From: Joe Russell-Wells
Sent: 14 December 2012 15:30
To: Neil Crowther
Subject: FP/155/12/DOC - Conditions 10, 11 and 19

Condition 10

Condition 11

Drop Kerbs with lockable bollards to prevent unauthorised entry

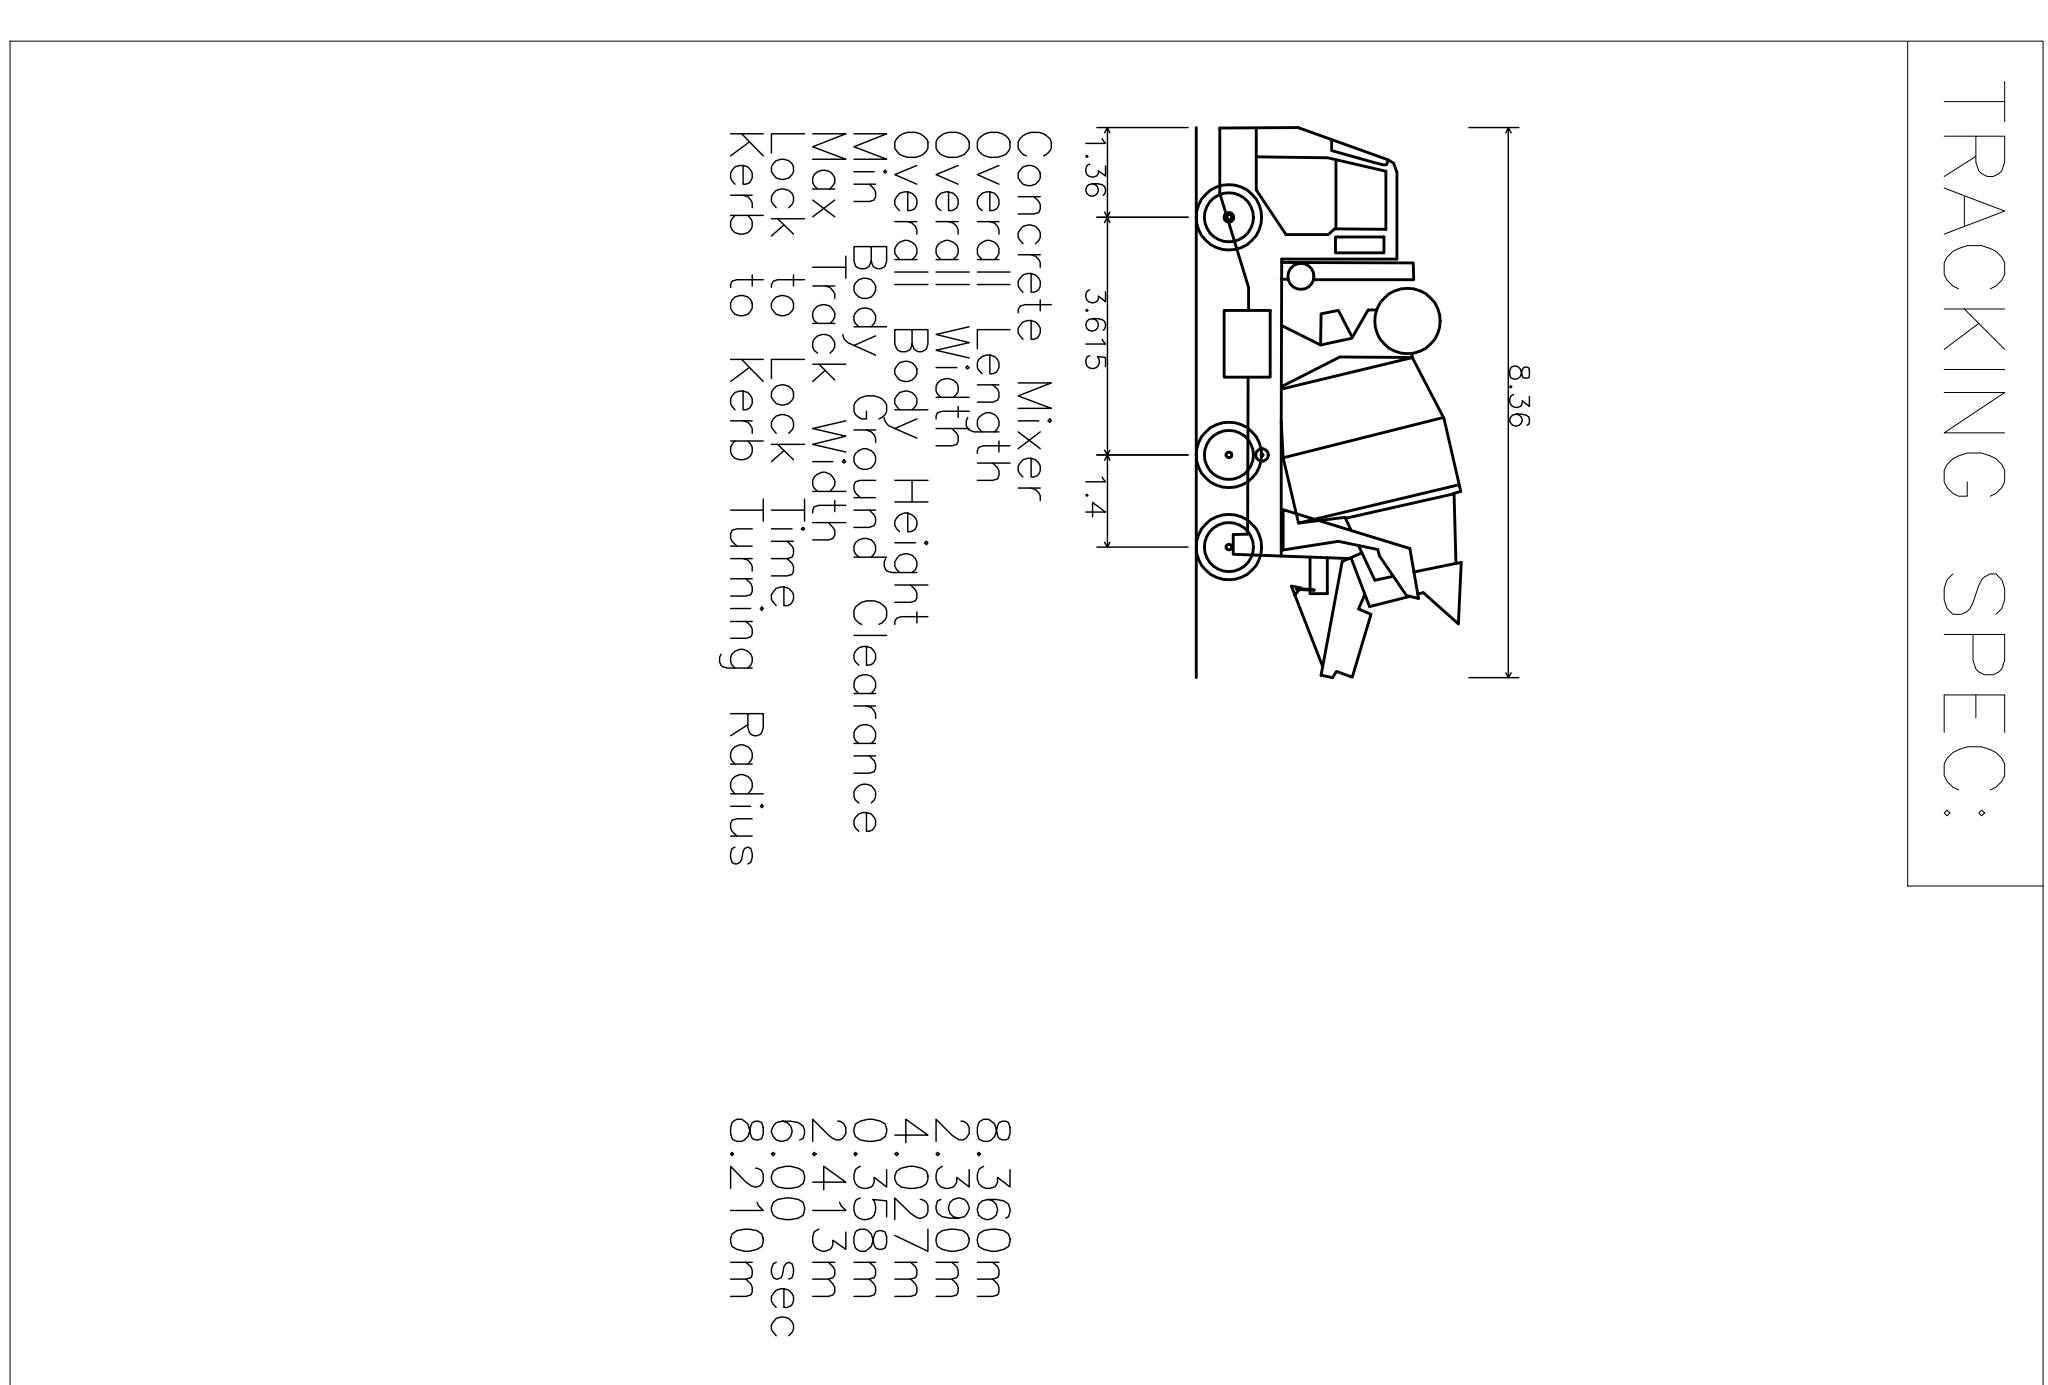
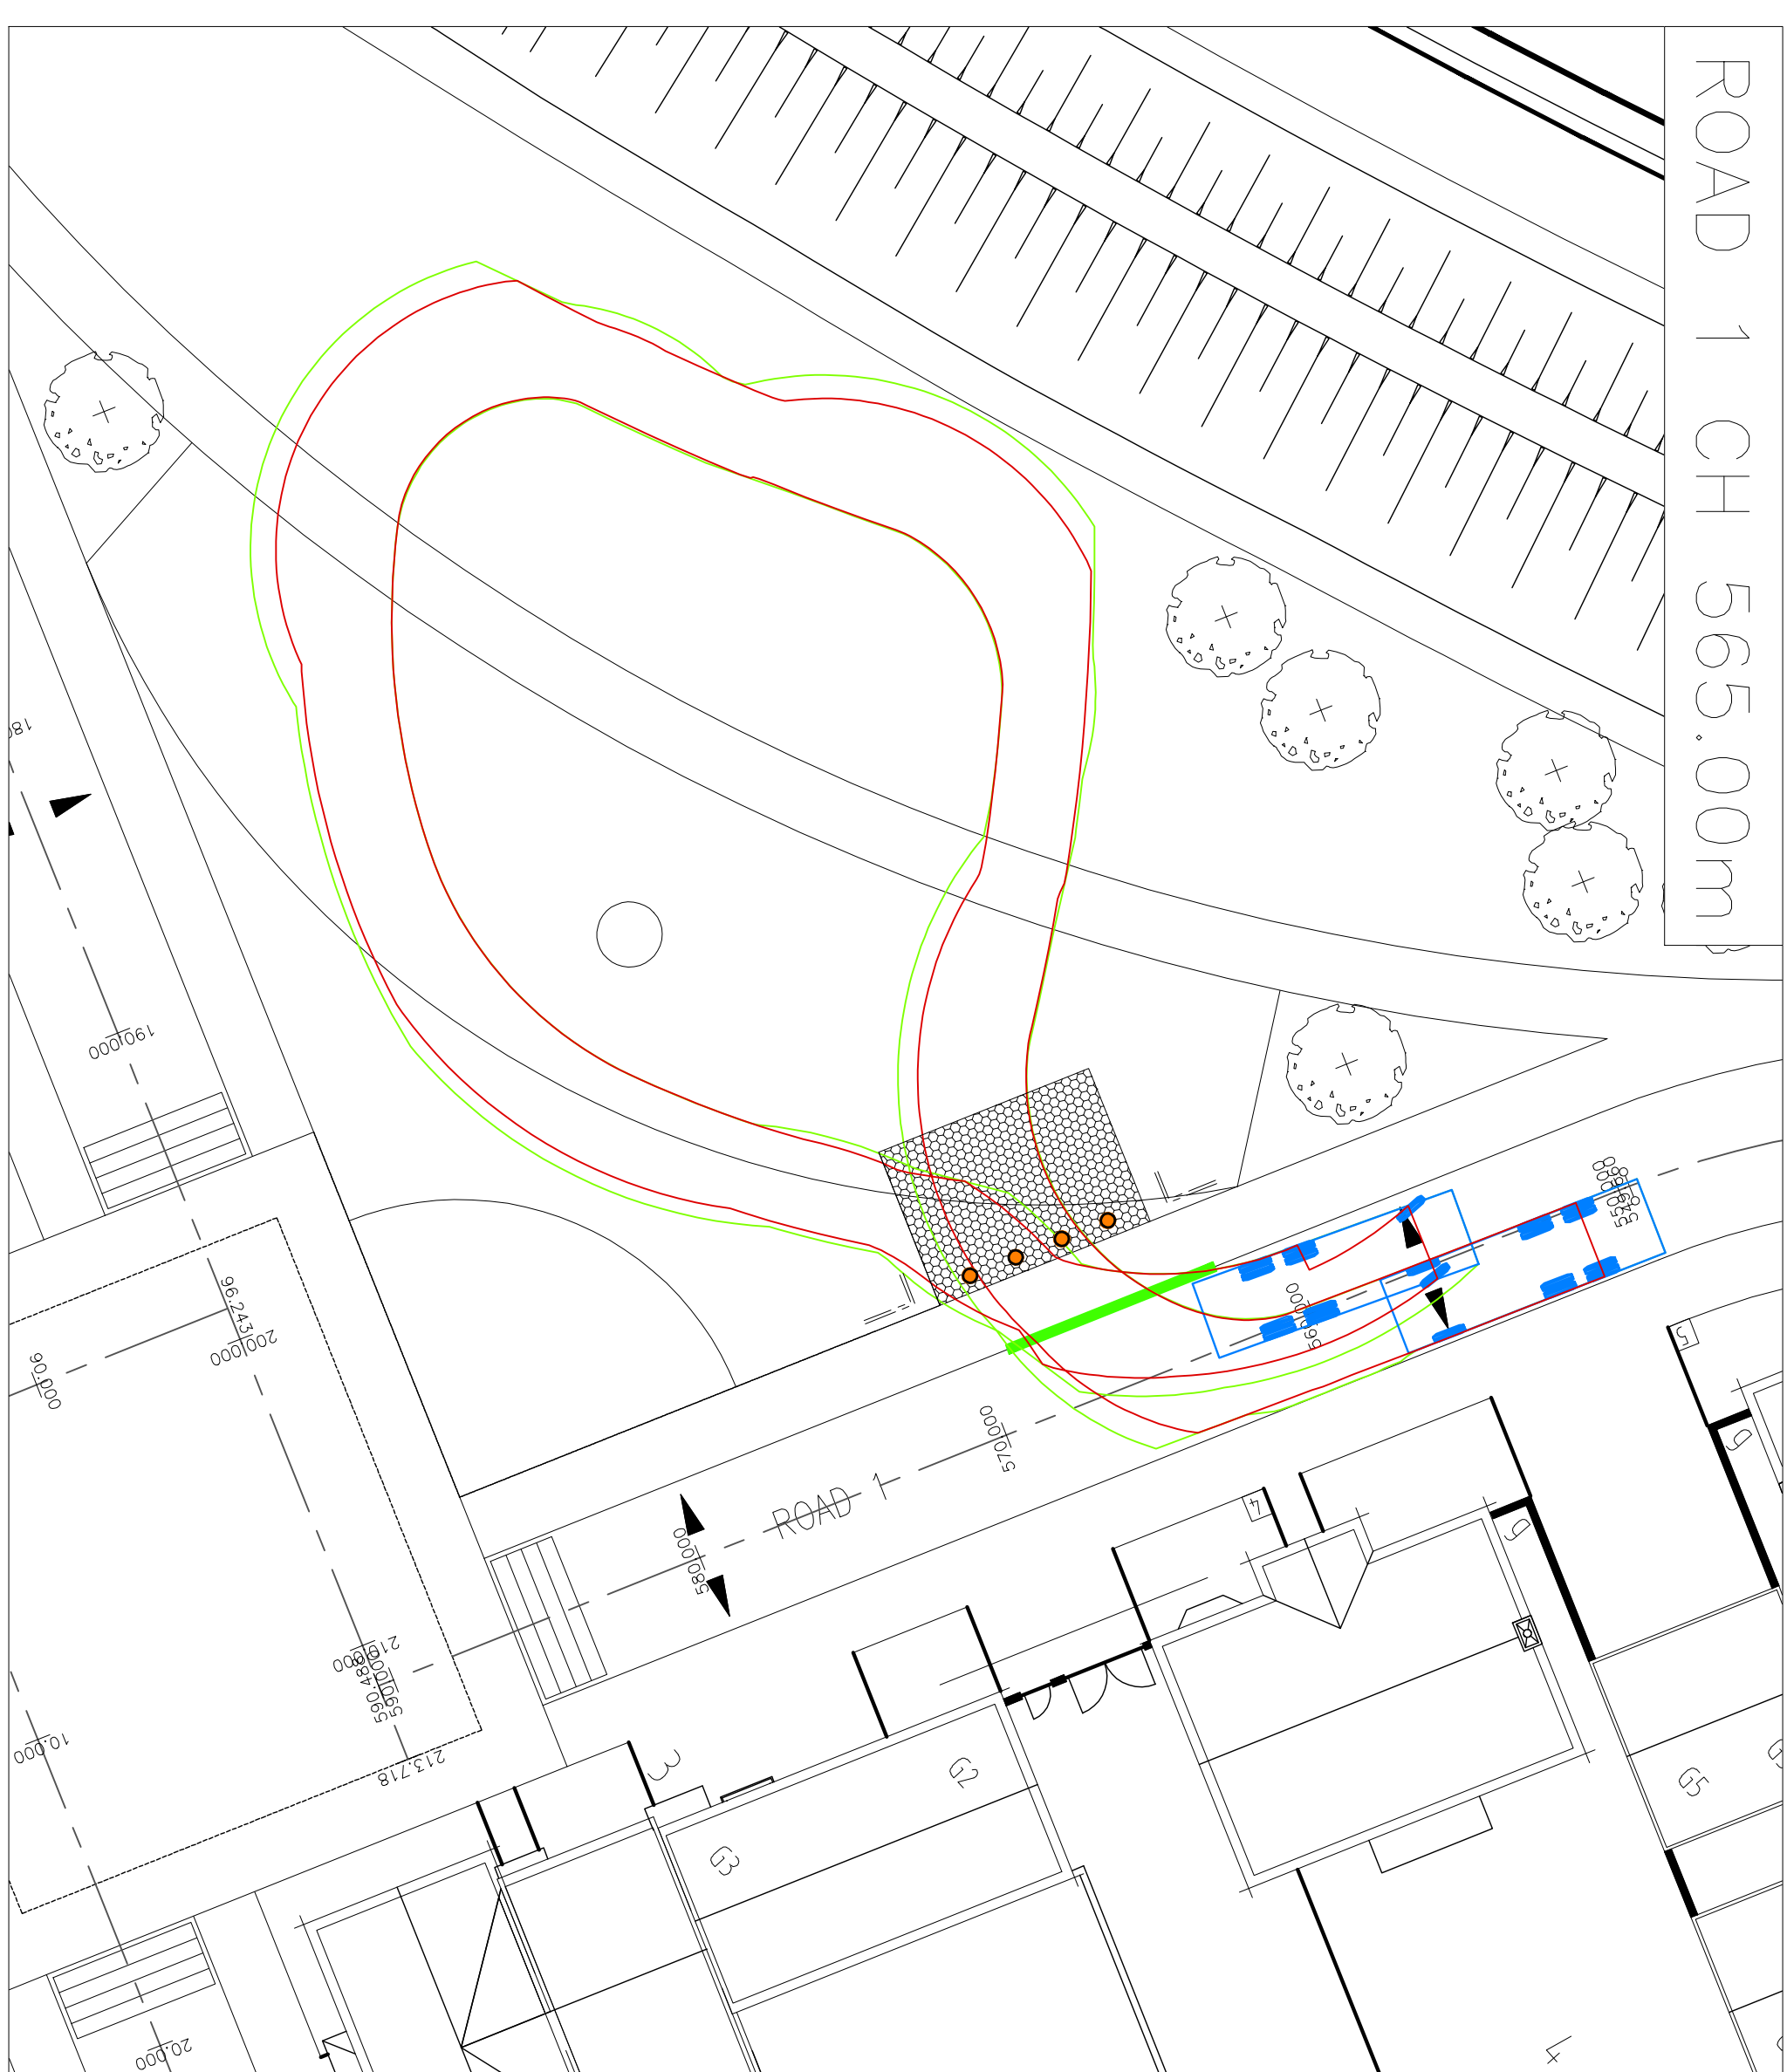
The information submitted does not prevent access by unauthorised vehicles. I do not therefore recommend release of the condition.

The trip rail detail is satisfactory; this together with previously submitted information I recommend release of the condition.
